Town & Country Planning Act 1990 (as amended)
Town & Country Planning (Development Management Procedure) (England) Order 2015

Application for Planning Permission for Works or Extension to a Dwelling

Development: Side dormer projection to existing first floor
Location: 32 Links Avenue Felpham PO22 7BX

sheet 1 a of 3

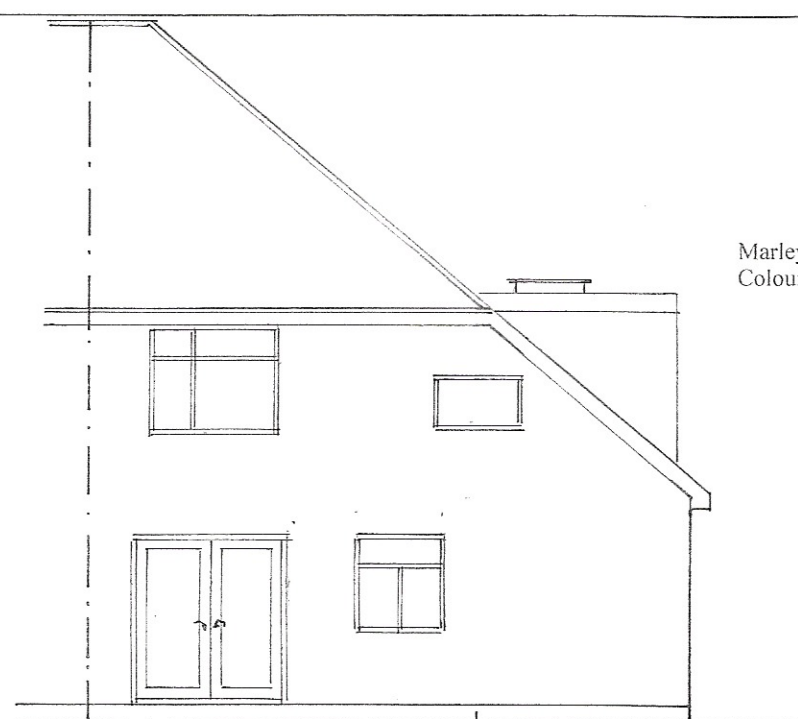
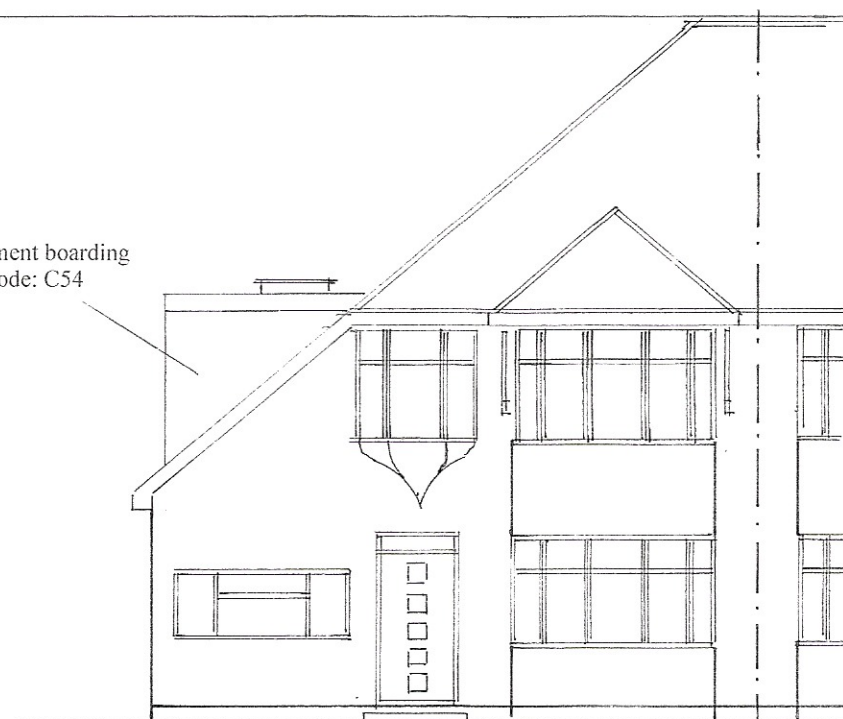
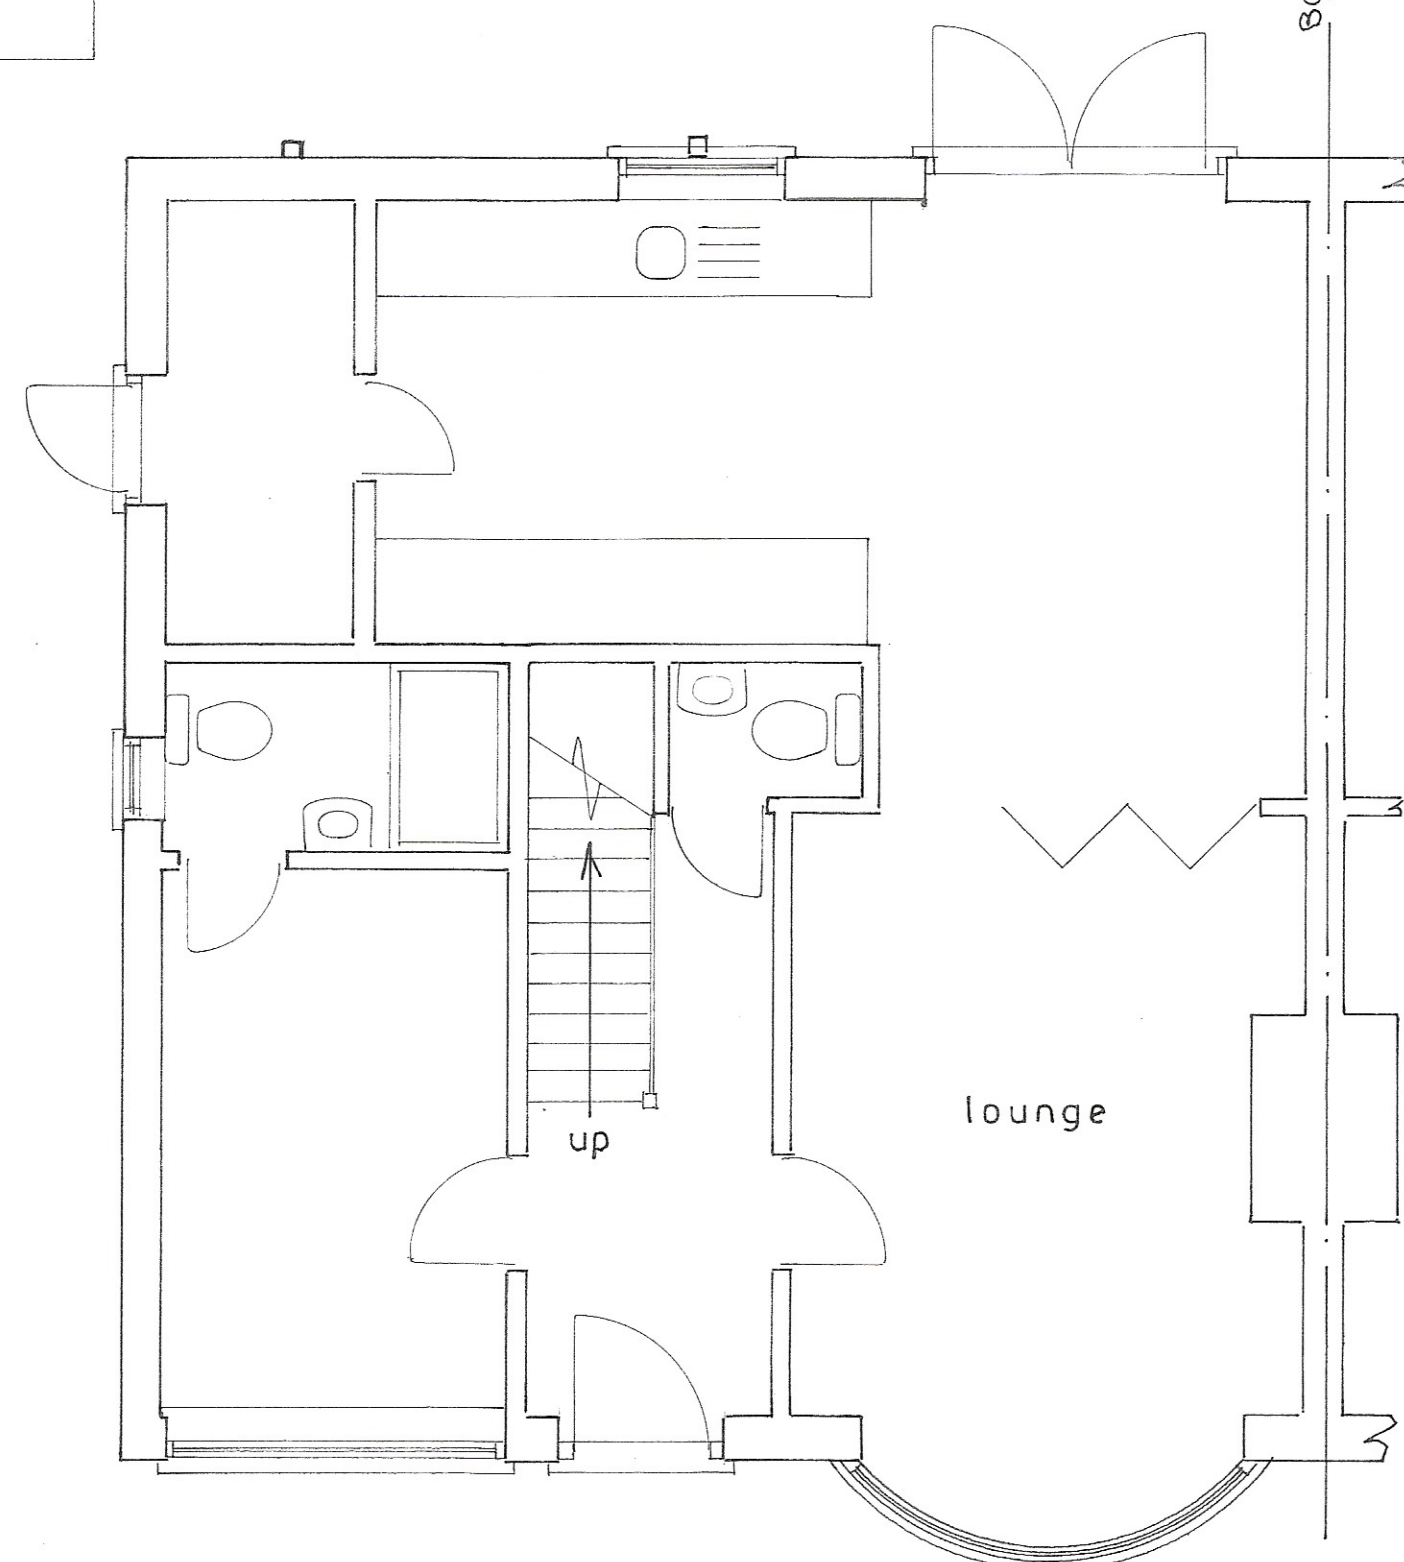
Please check the North, South and West aspect Elevations have been labelled correctly as on checking the front of the property appears to be on the West Elevation. Amend accordingly and resubmit, or clarify if correct.
